DRB Application No.: 07DRB-70019 (SPB)
Project Name: JOURNAL CENTER, UNIT 2
Agent: Chesh Ent Inc.

OFFICIAL NOTICE OF DECISION

5. Project# 1006503
07DRB-70019 MAJOR - SDP FOR BUILDING PERMIT

CHESH ENT INC request(s) the above action(s) for all or a portion of Lot(s) 6, **JOURNAL CENTER, UNIT 2**, zoned IP, located on MASTHEAD NE BETWEEN WASHINGTON NE AND JEFFERSON NE containing approximately .53 acre(s). (D-17)

SITE PLAN FOR BUILDING PERMIT

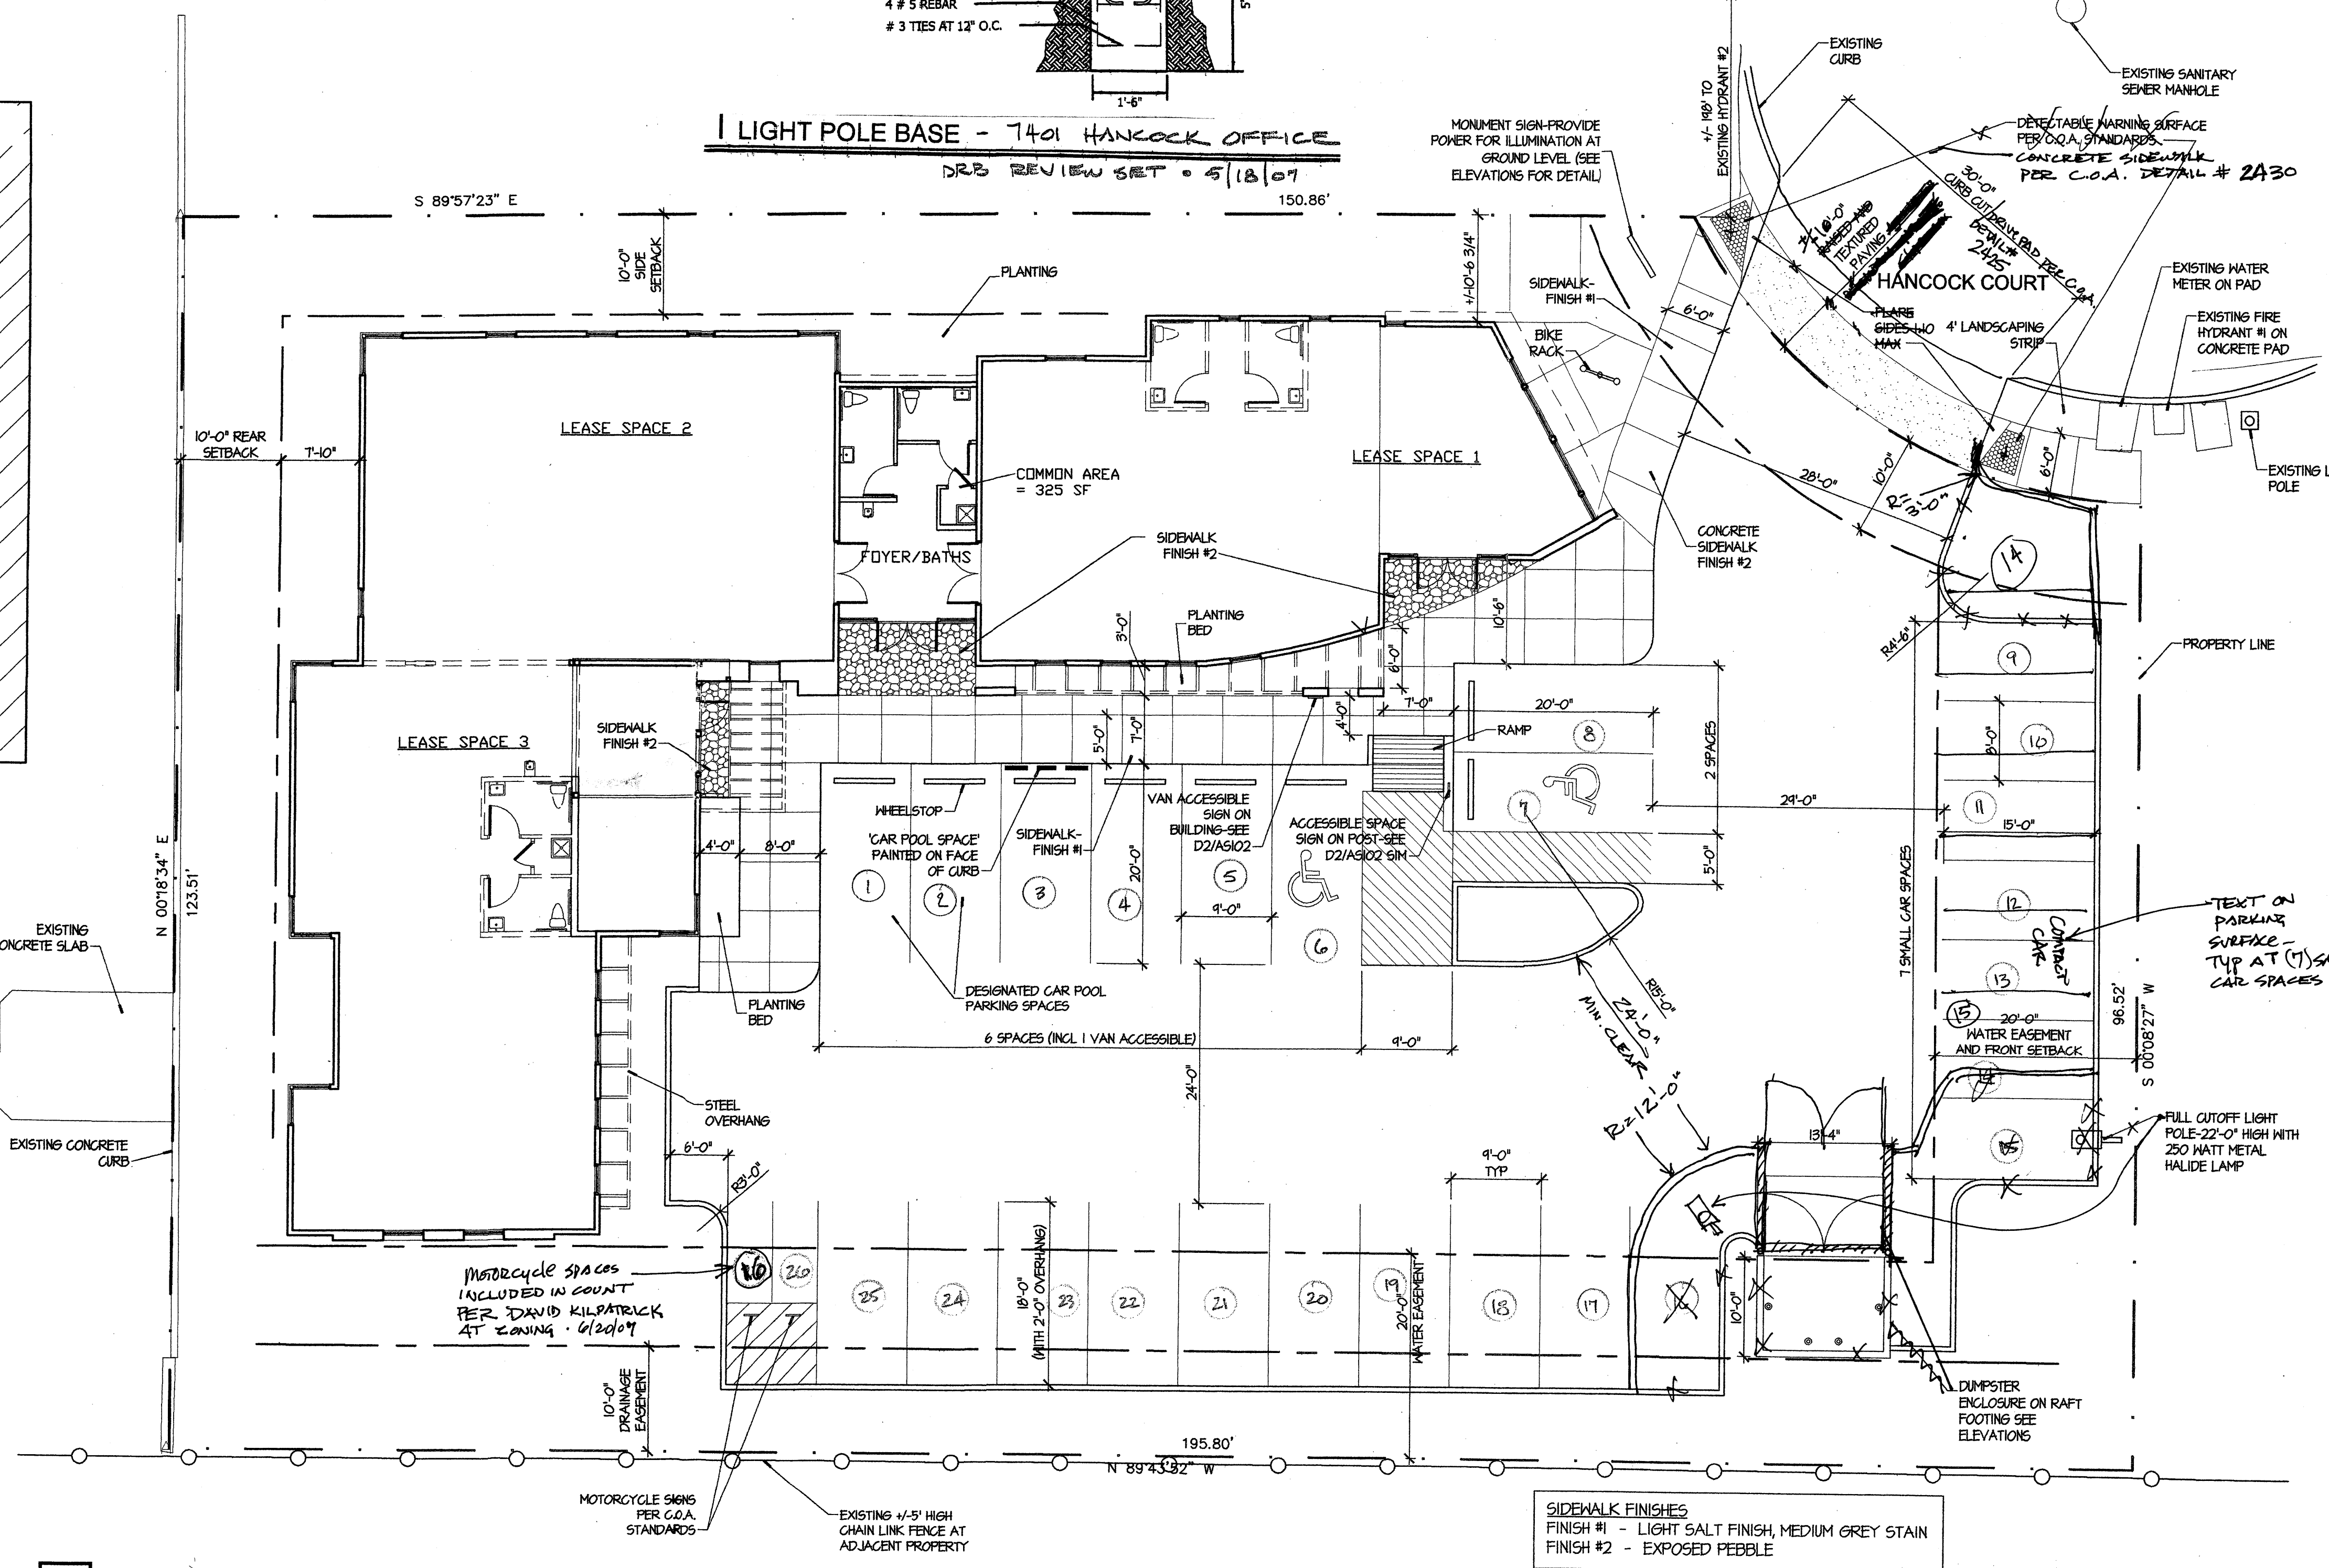
- TRANSPORTATION: X- 3 COPIES 15 DAY APPEAL PERIOD
- X- CITY STANDARD DRAW A2'S
- X - PARKING COUNTS
- X - SMALL CAR SPACE PRINTING
- X - ADA RAMP ?

- TRANSPORTATION: X- 3 COPIES 15 DAY APPEAL PERIOD
- X- CITY STANDARD DRAW #25
- X- PARKING COUNTS
- X - SMALL CAR SPACE PRINTING
- X - ADA RAMP ?

Work within public right-of-way requires either a work order or the City Standard Drawing Numbers need to be referenced. Where is the curb cut for the lot to the north? (will the proposed curb cut interfere with ADA compliance?) The parking counts are two short. (Motorcycle parking is in addition to the required counts?) Small car spaces need to be painted on the pavement. How will the 6' pedestrian path work with ADA compliance at the curb cut?

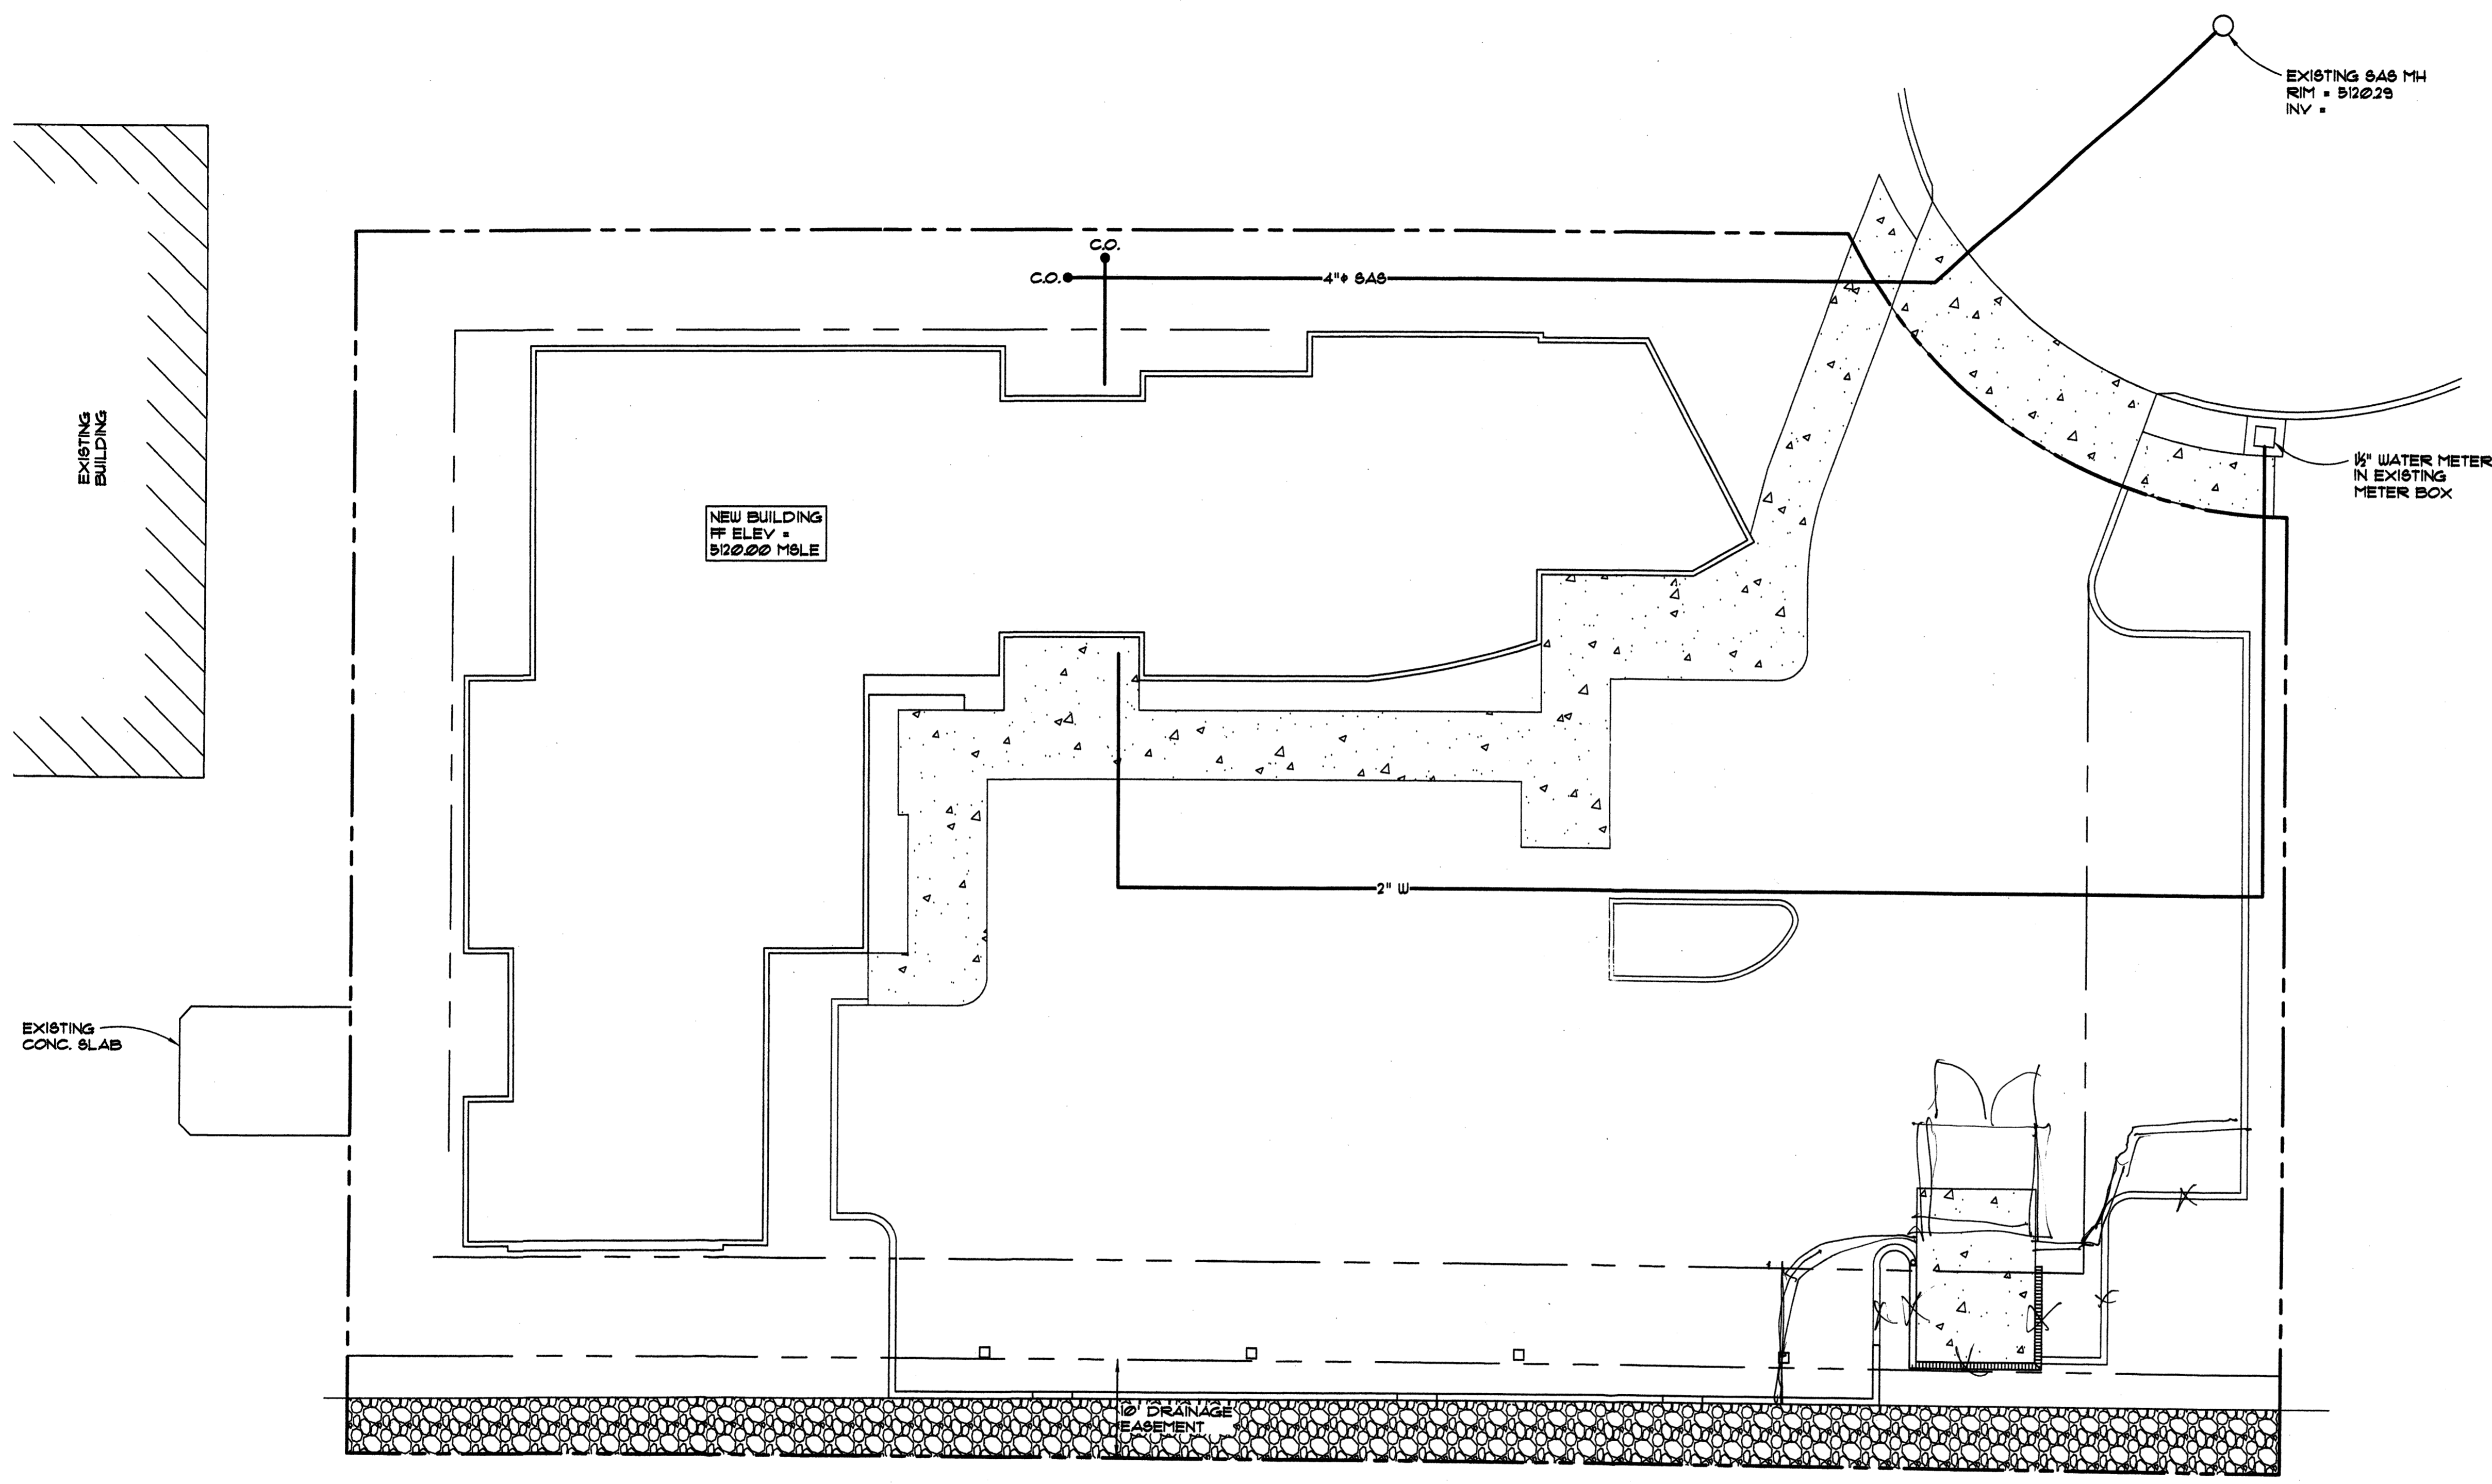
- UTILITIES: Remove encroachments (Light Pole) (Dumpster) from 20' waterline Easement.
- D.K. - MJB

- UTILITIES: Remove encroachments (Light Pole) (Dumpster) from 20' waterline Easement.
-
-
